**From:** Christopher Ashworth [REDACTED]  
**Sent:** Wednesday, 24 May 2017 12:25 PM  
**To:** Pilar Aberasturi  
**Cc:** Amy Watson; Brendon Roberts; Bill MacKay  
**Subject:** Section 96 Modifications to the Australian Technology Park, Eveleigh (SSD 7317 MOD 1 and MOD 2)

**NOTICE OF SECTION 96 MODIFICATIONS TO THE AUSTRALIAN TECHNOLOGY PARK, EVELEIGH (SSD 7317 MOD 1 AND MOD 2)**

**OUR REF: R/2015/37/C**

MIRVAC - AUSTRALIAN TECHNOLOGY PARK - BUILDING 1

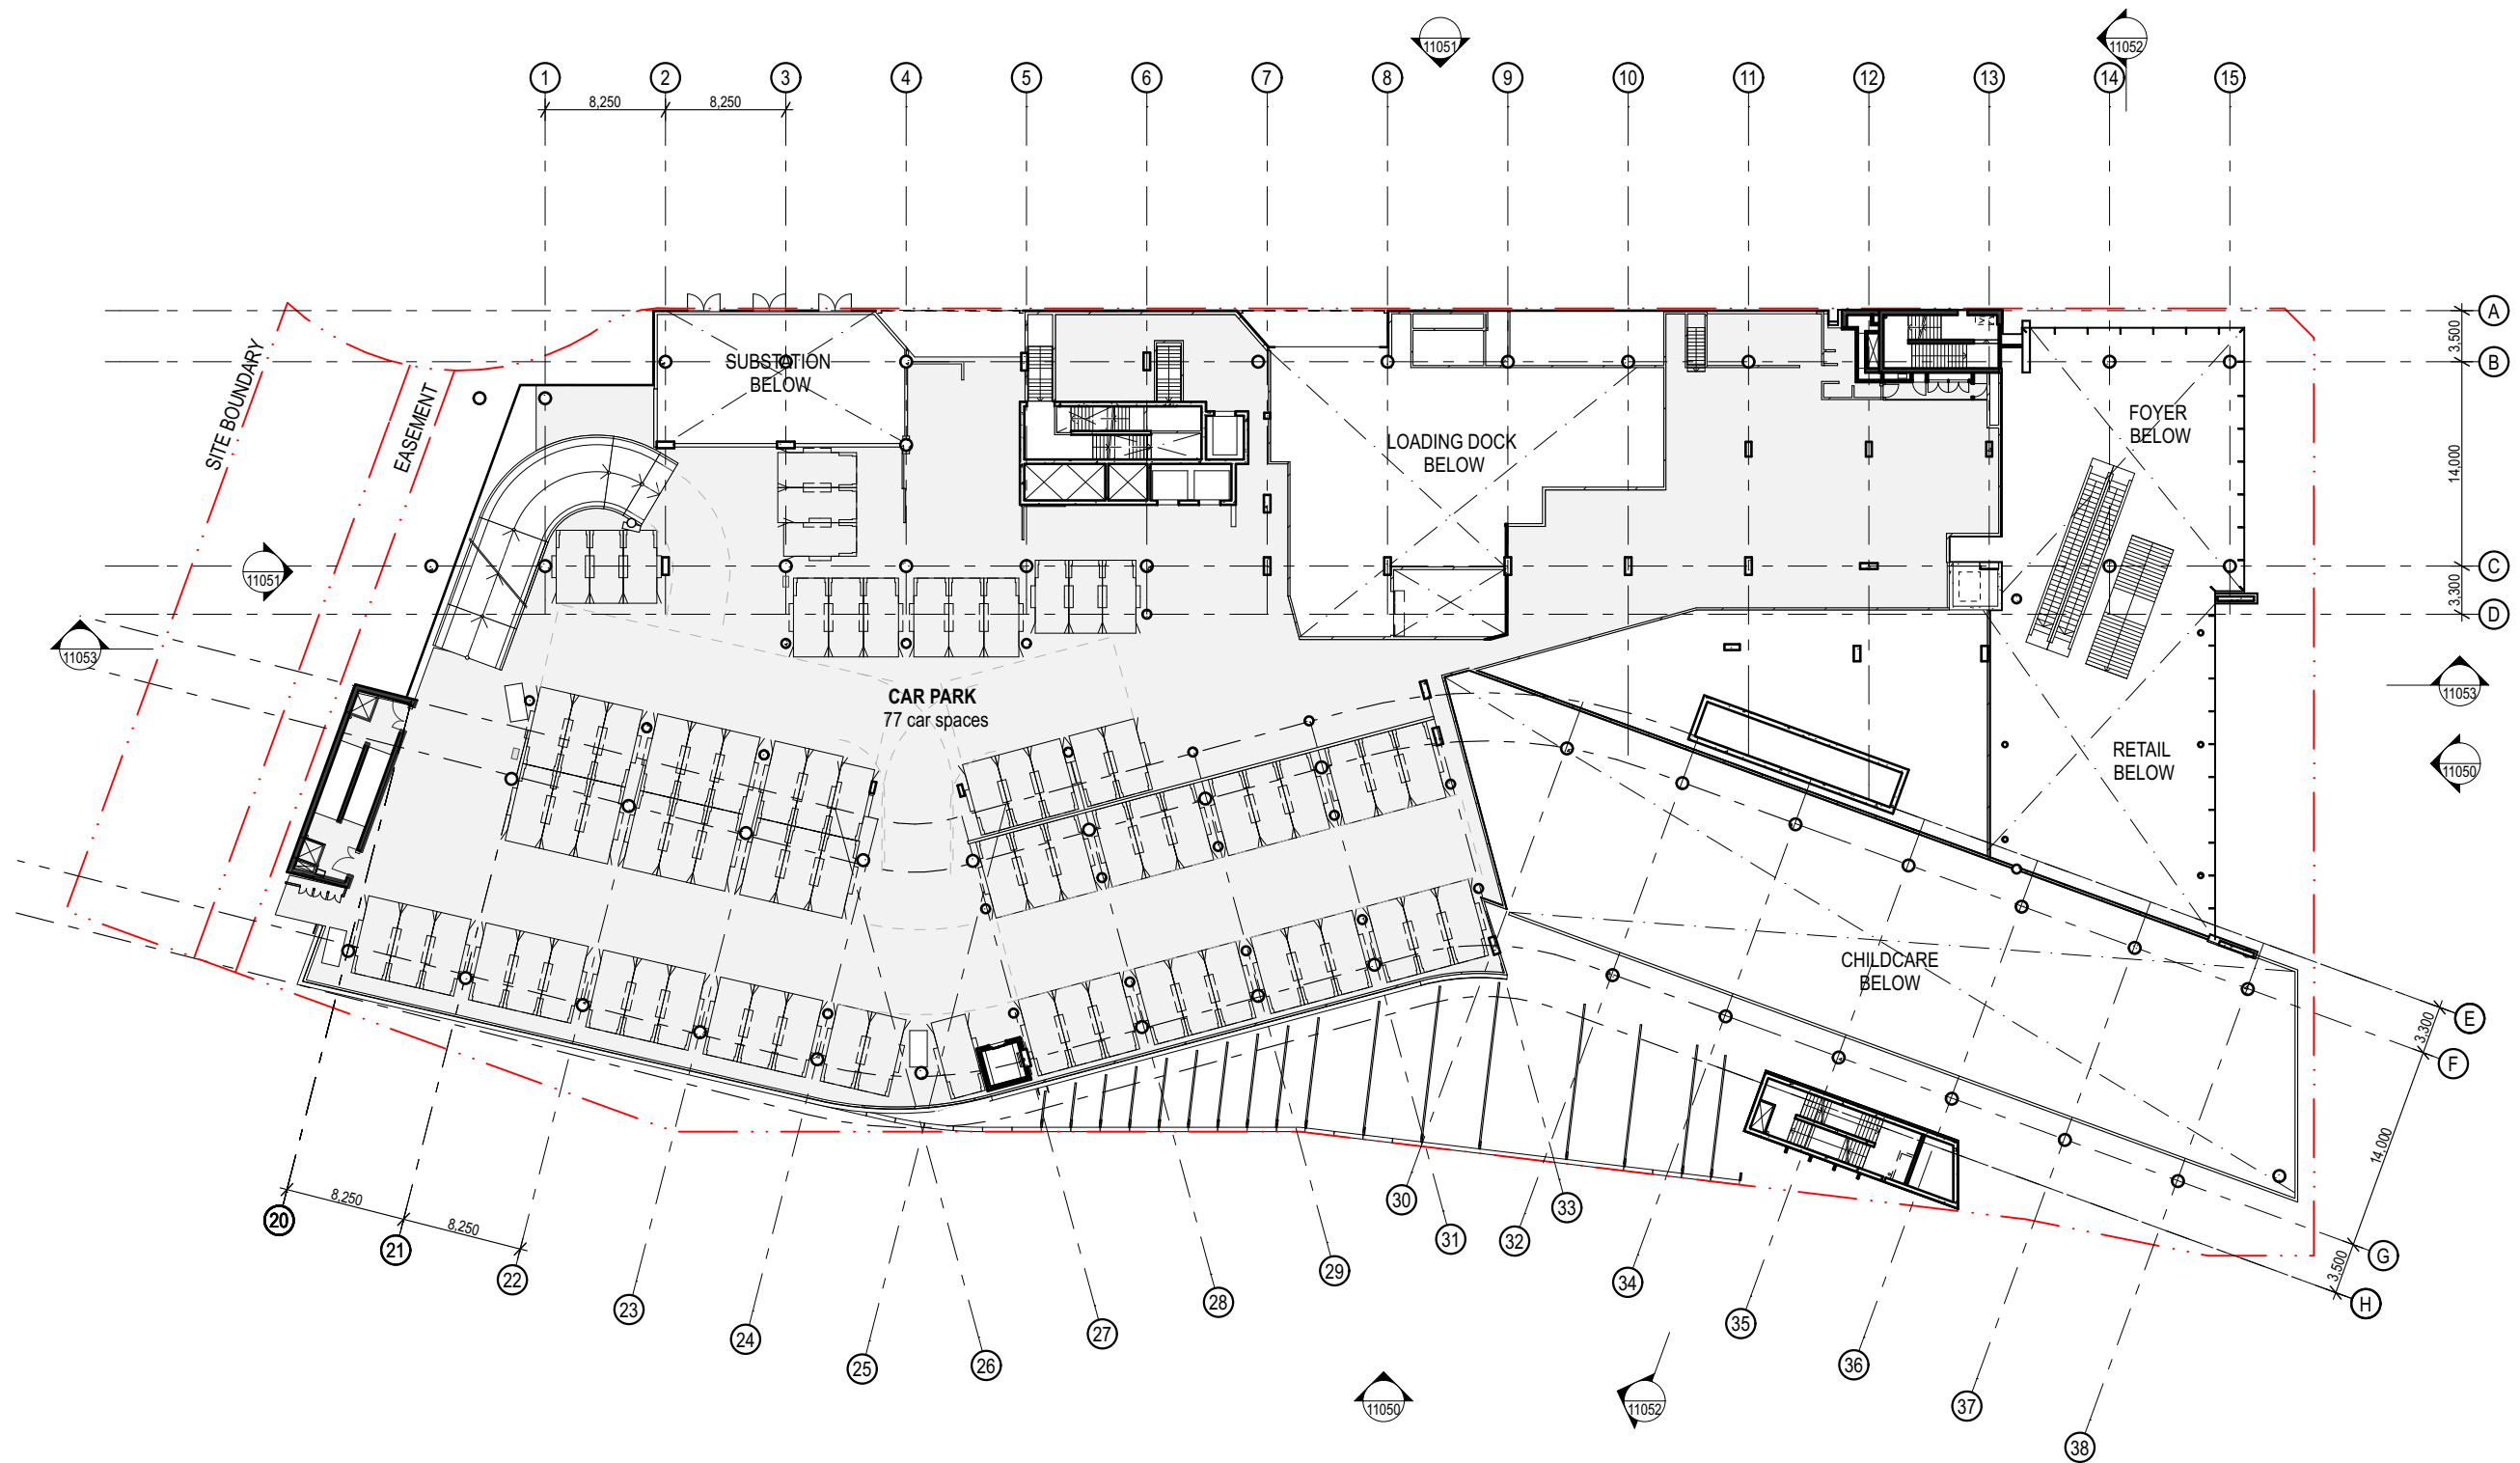
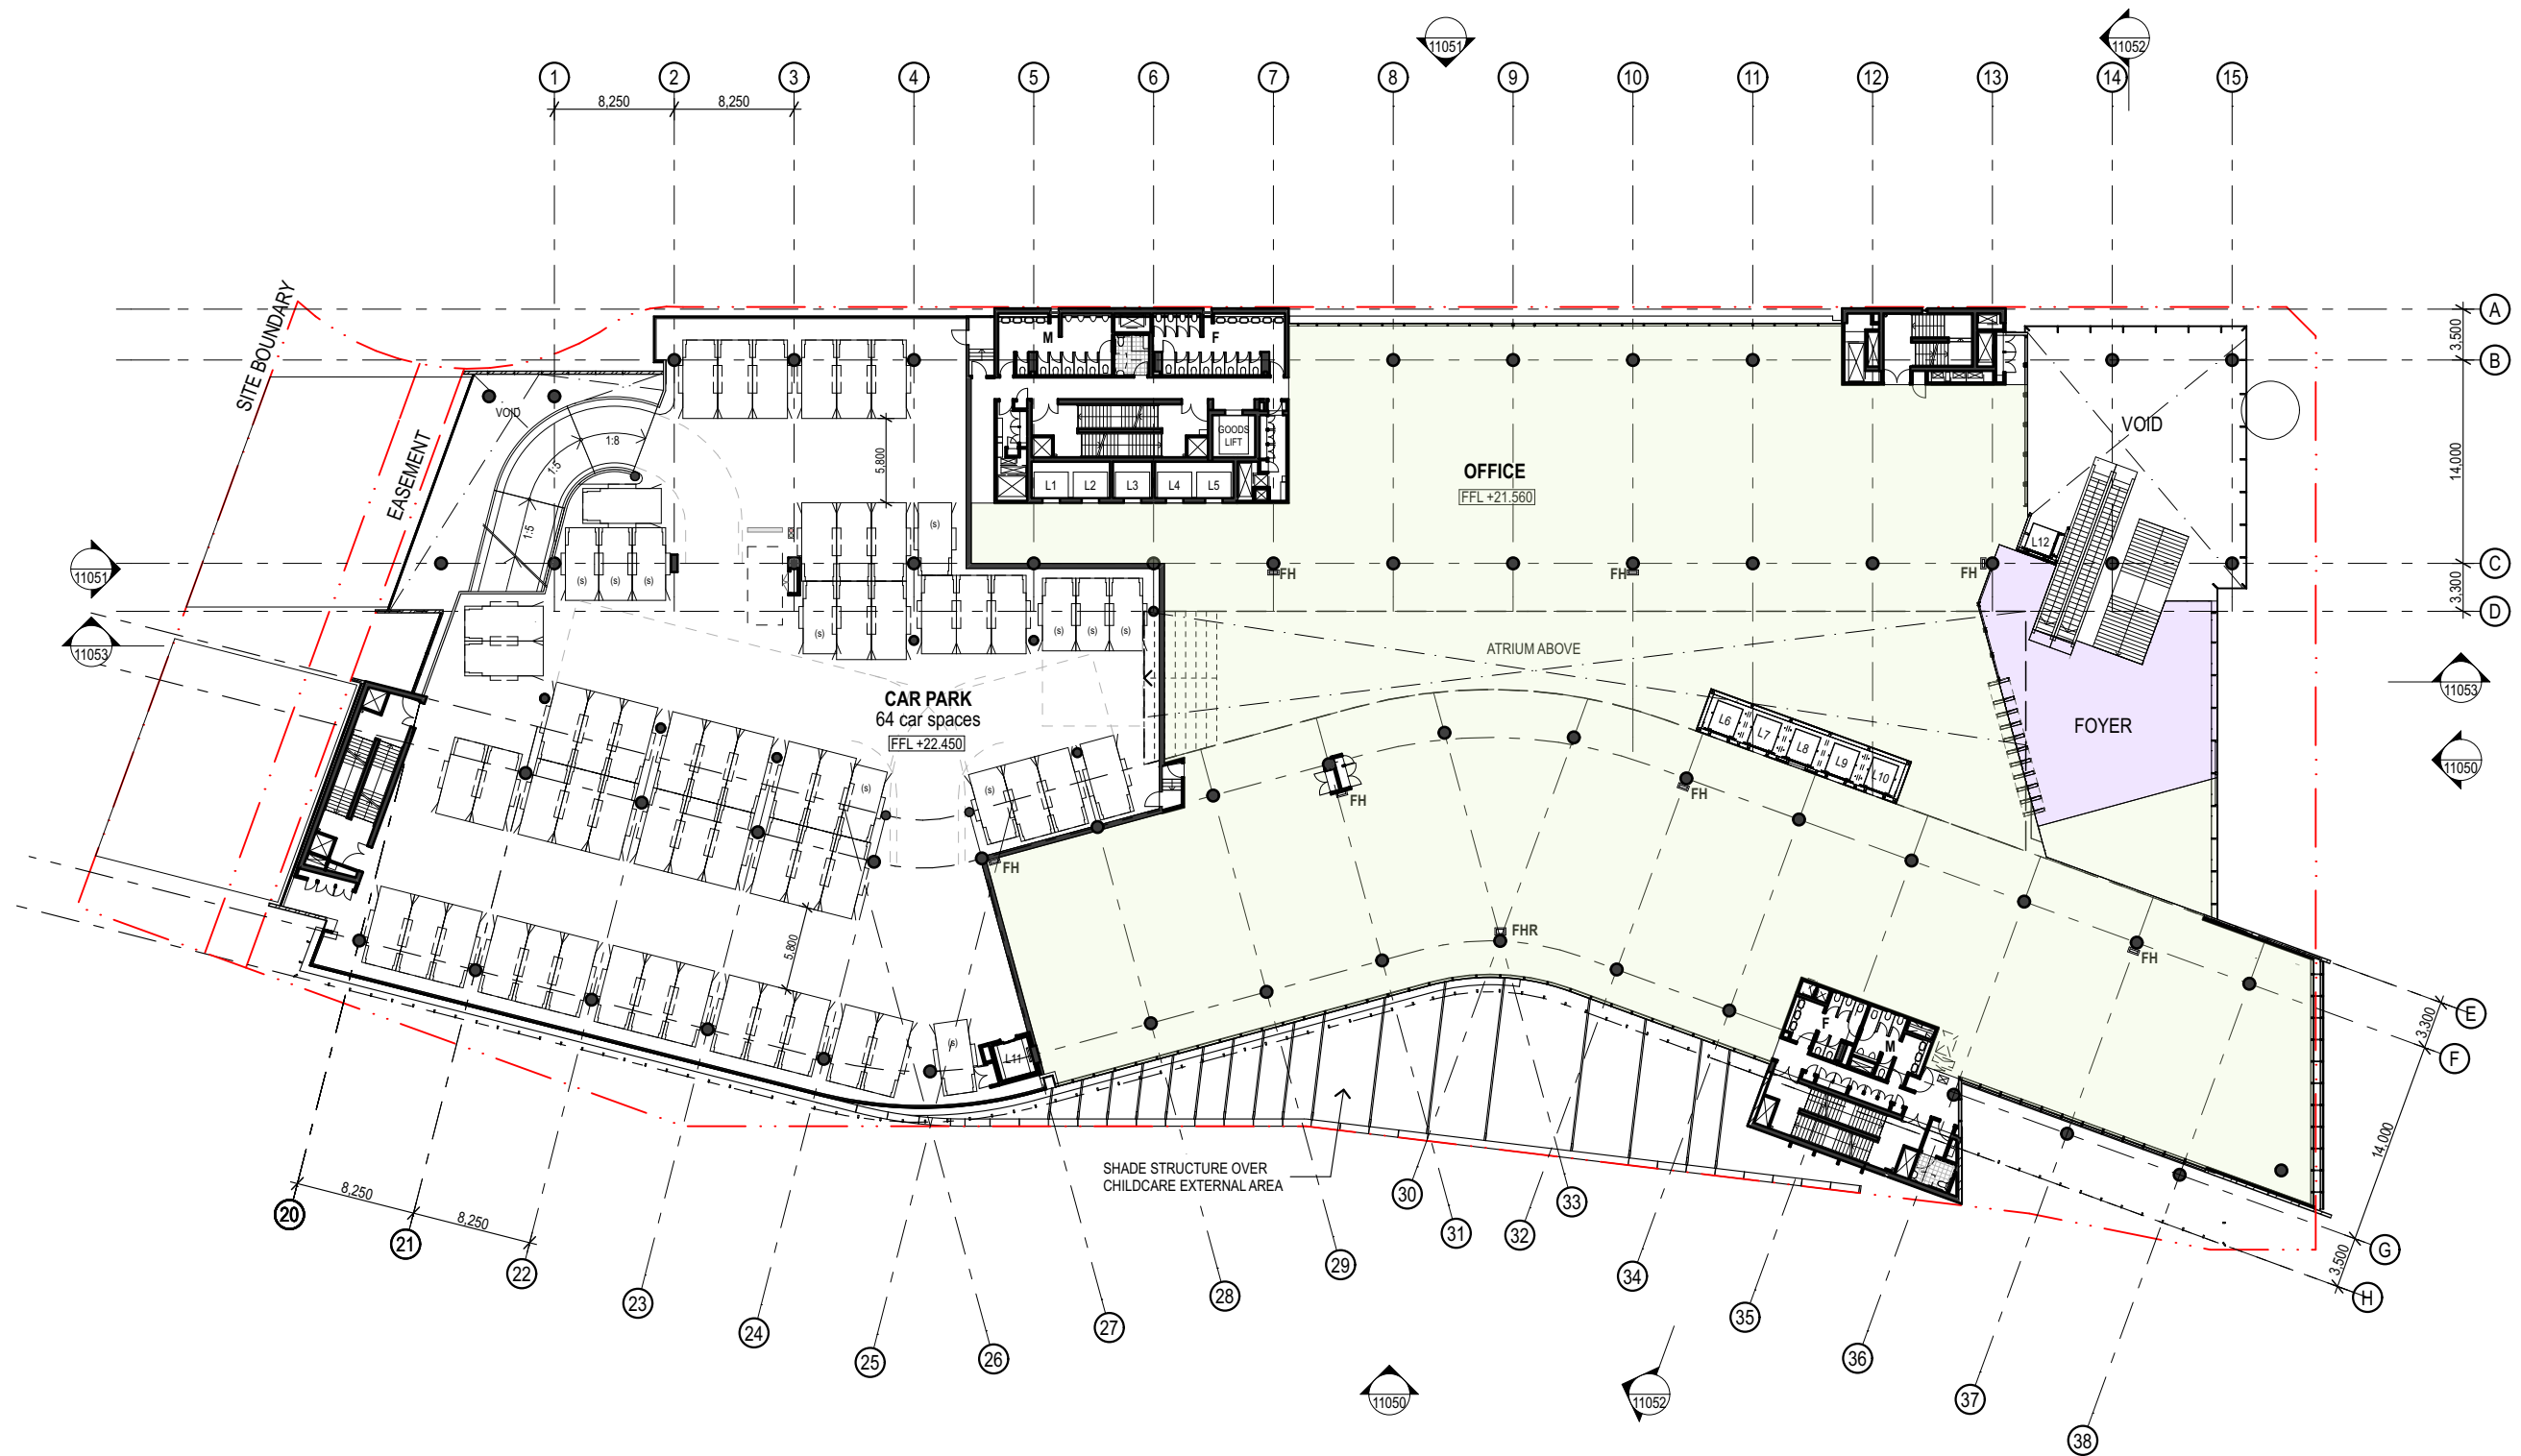
The City also objects to the deletion of secure bicycle parking from the basement areas.
